Your Ref: OWQC24954
Our Ref: BR/233/19/PL
Please ask for:
Mr S Davis

Part change of use of ground floor & formation of a first floor rear extension to create 2
No self-contained studio flats with associated refuse/ recycling & cycle store
(resubmission following BR/63/18/PL).

77 Aldwick Road Bognor Regis

Drawing
PROPOSED FLOOR PLANS

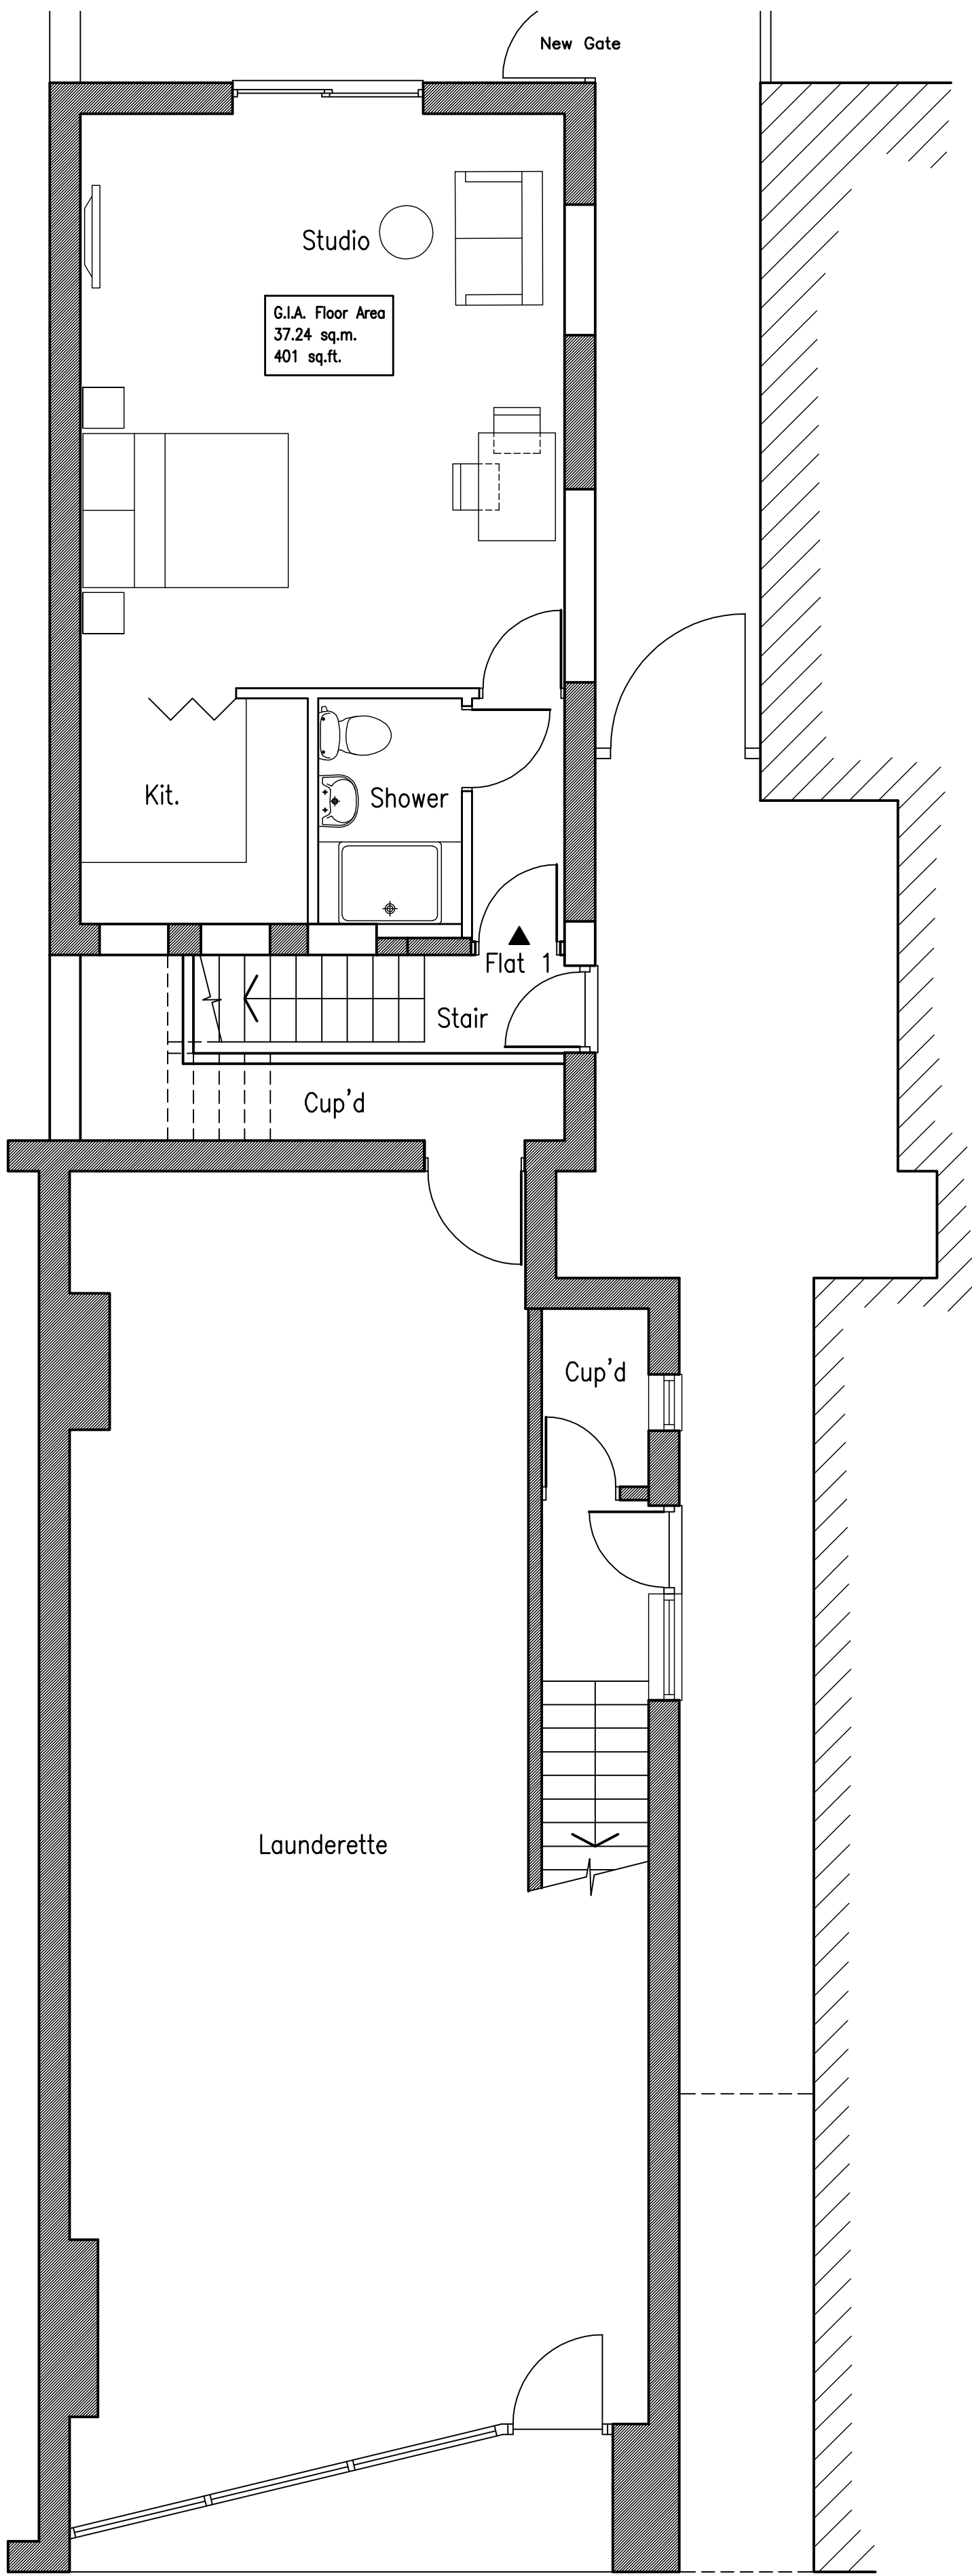
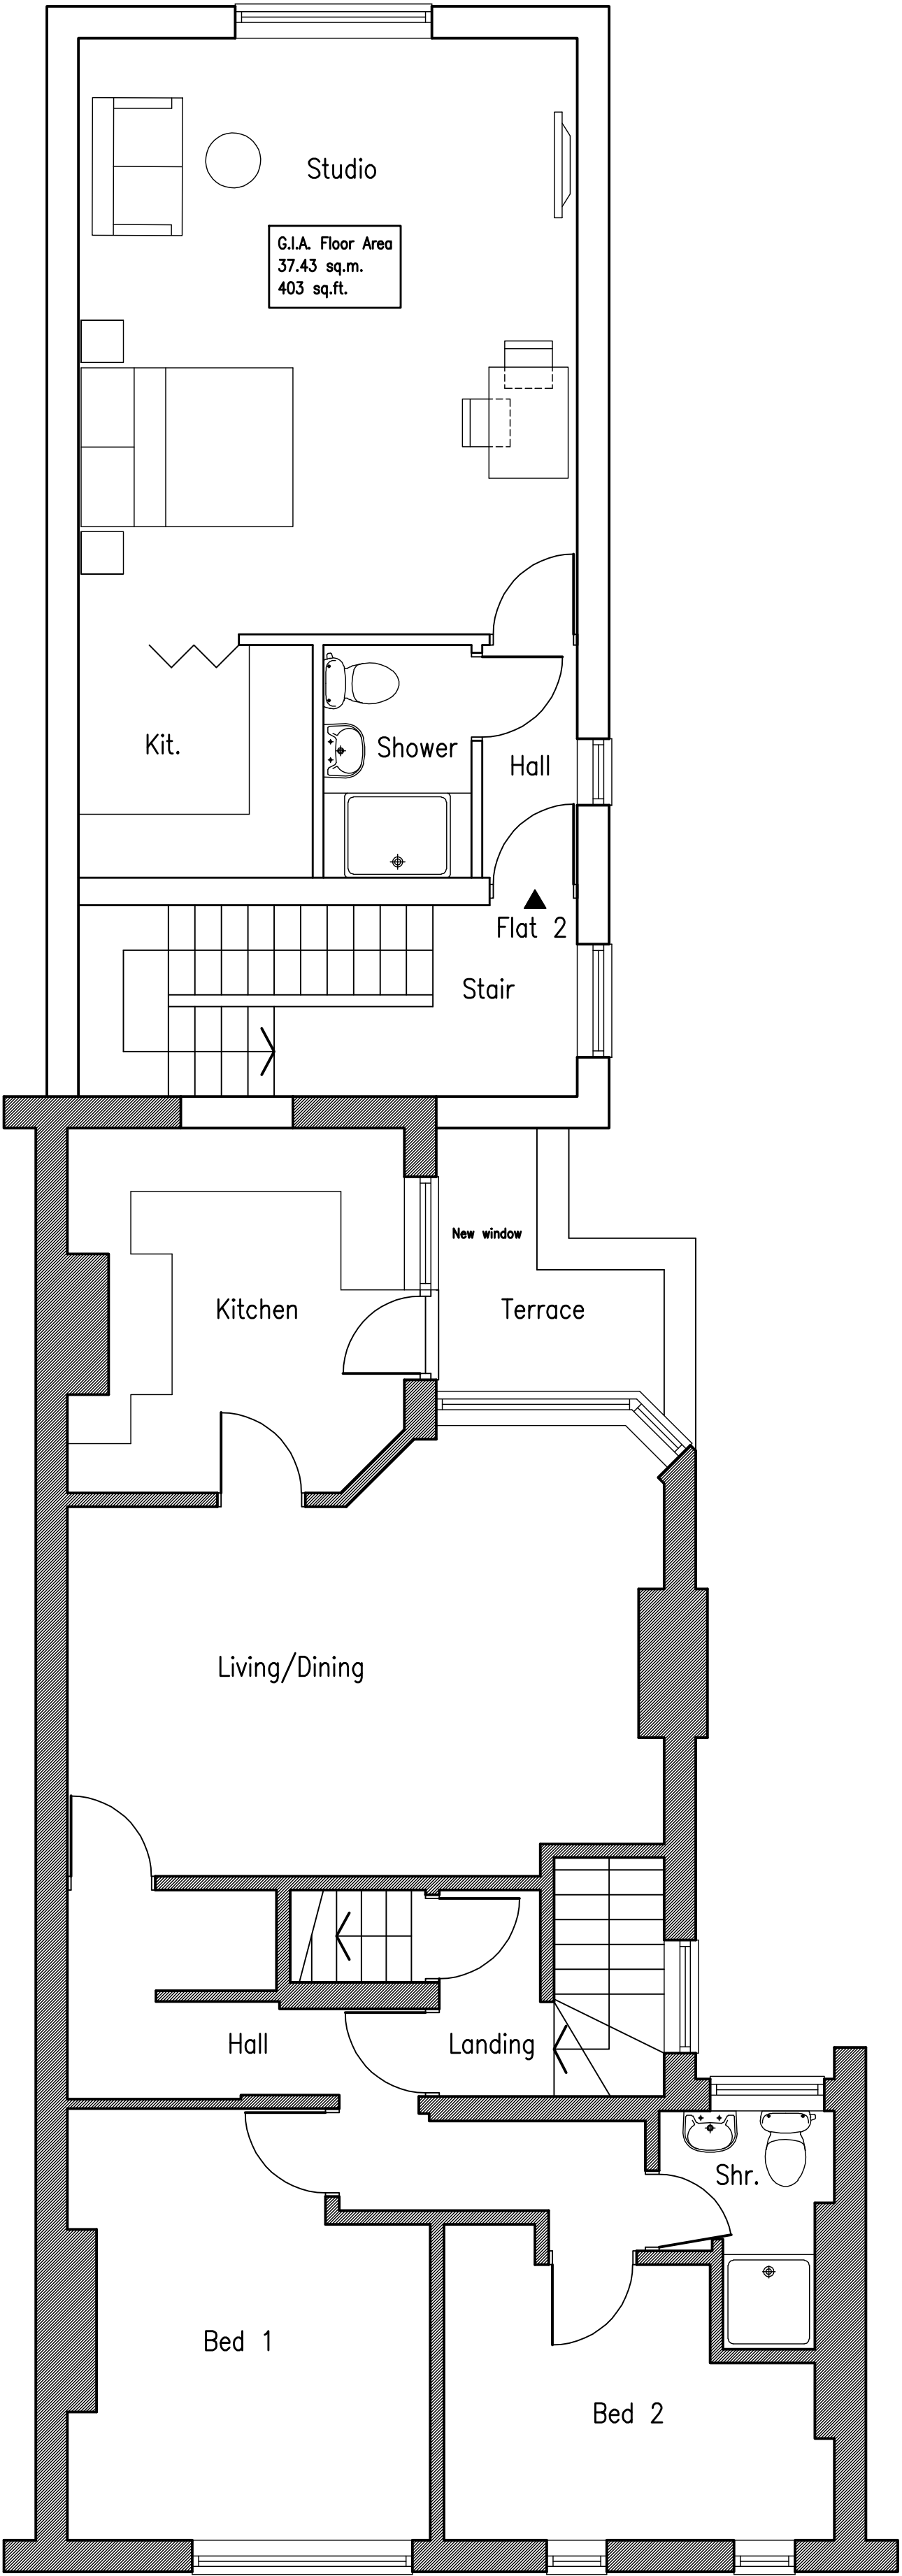
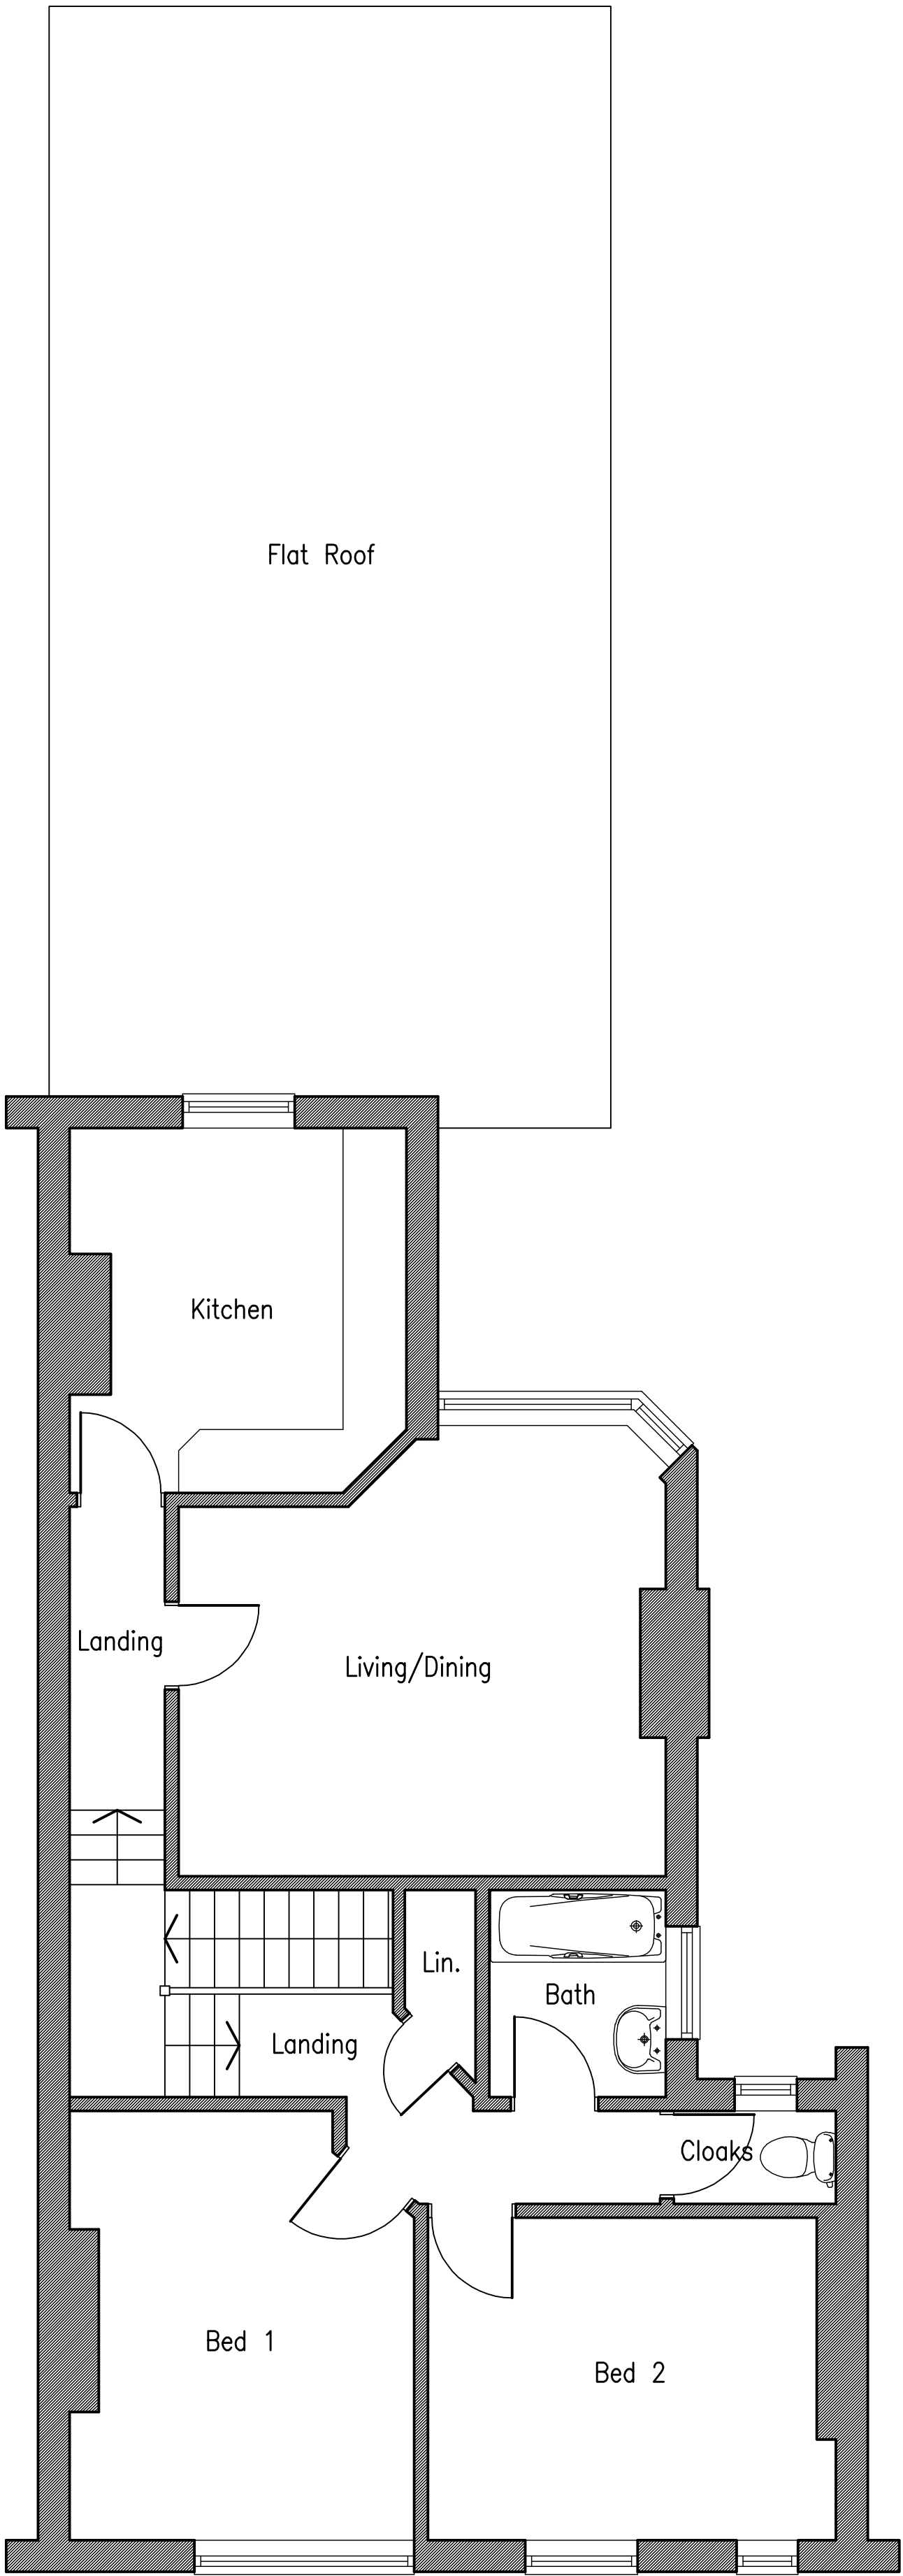
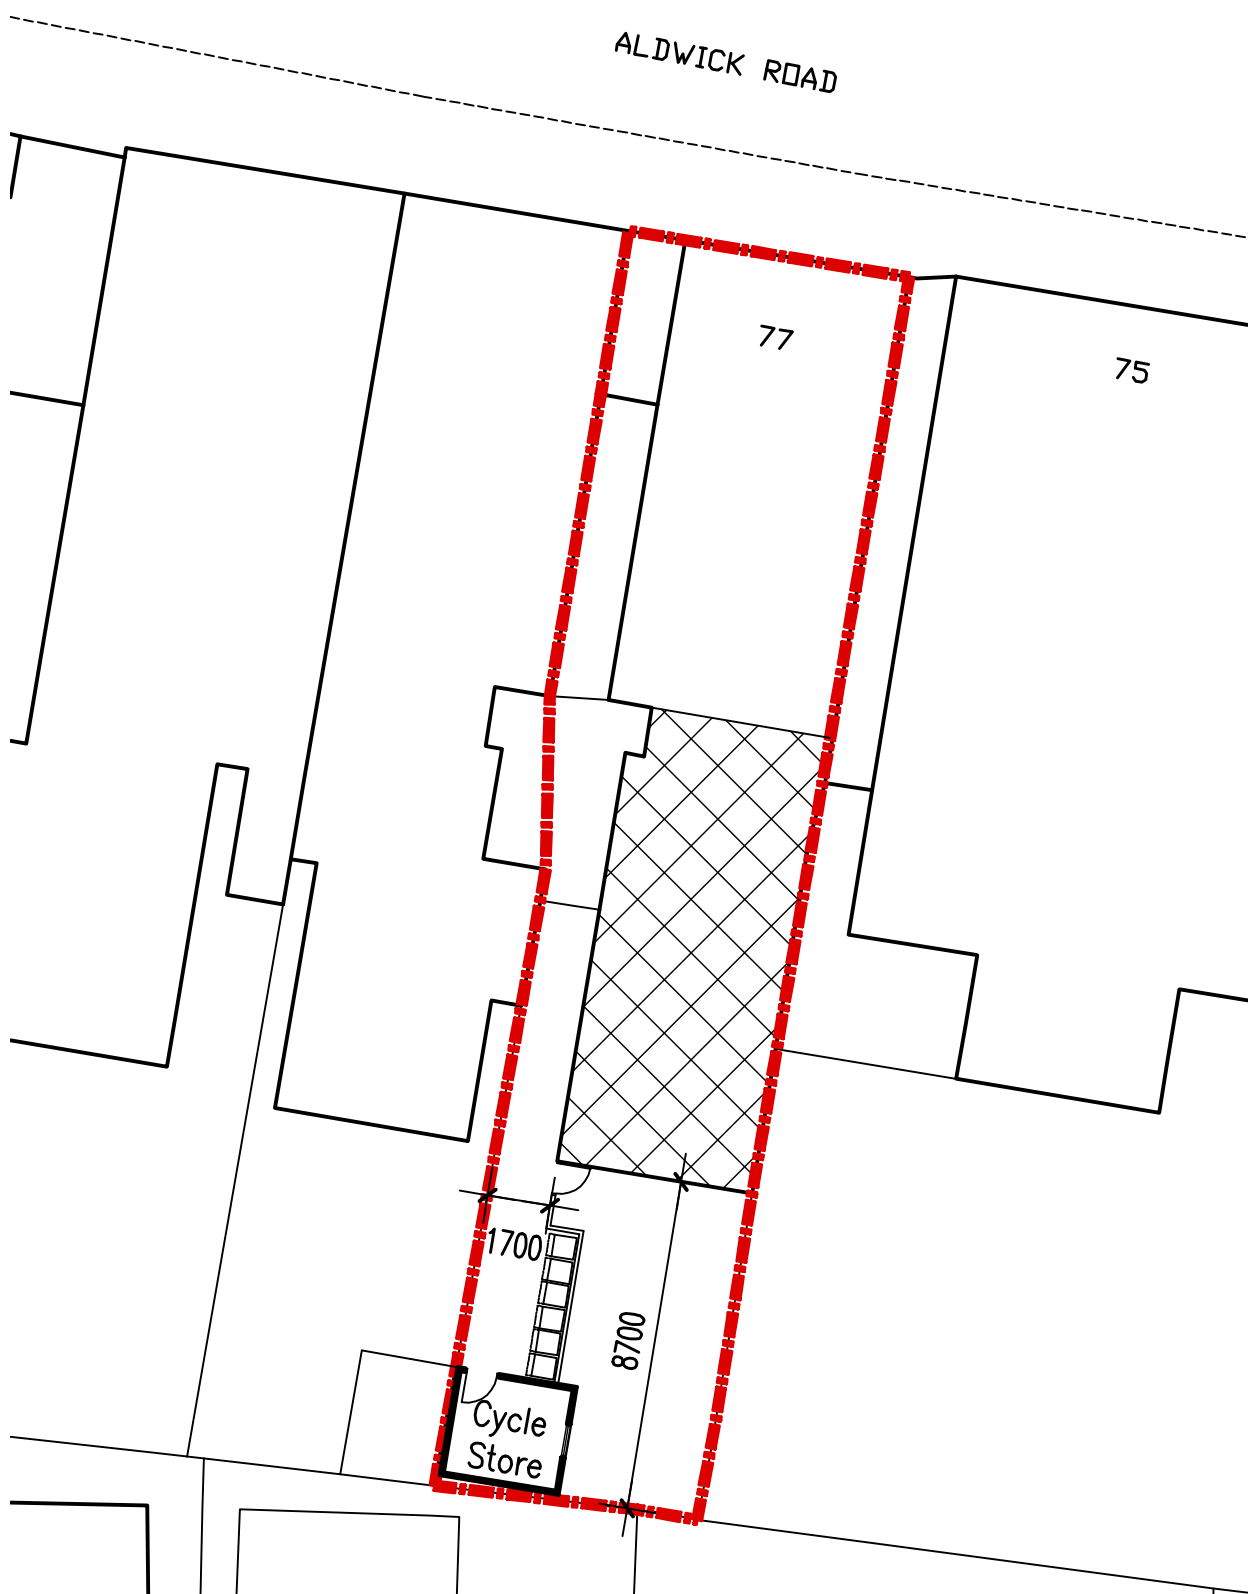
OBJECTION The scale of the proposed first-floor extension to the rear of 77 Aldwick Road will result in an overbearing impact on - and loss of outlook to - the amenity of the existing windows of residential flats in the rear of 73-75 Aldwick Road to the east and 79 Aldwick Road to the west. In addition, there will be a harmful loss of sunlight and overshadowing of the two large residential windows on the closest part of the rear of 79. The proposal is therefore contrary to policy GEN7 of the Arun District Local Plan; the National Planning Policy Framework; and policies DDM1 & DDM4 of the Arun Local Plan 2011-2031.

The new first floor studio windows will look out towards the rears of Nos. 10 & 14/16 Stocker Road at a distance of only around 8.8m. This will result in a loss of privacy to number 10's private residential garden. The new first floor kitchen, hall and stair windows will face towards the flank residential windows of 79 Aldwick Road, resulting in a loss of privacy to these windows and a harmful effect on the amenity of existing occupiers. The proposal is therefore contrary to policy GEN7 of the Arun District Local Plan; the National Planning Policy Framework; and policies DDM1 & DDM4 of the Arun Local Plan 2011-2031.
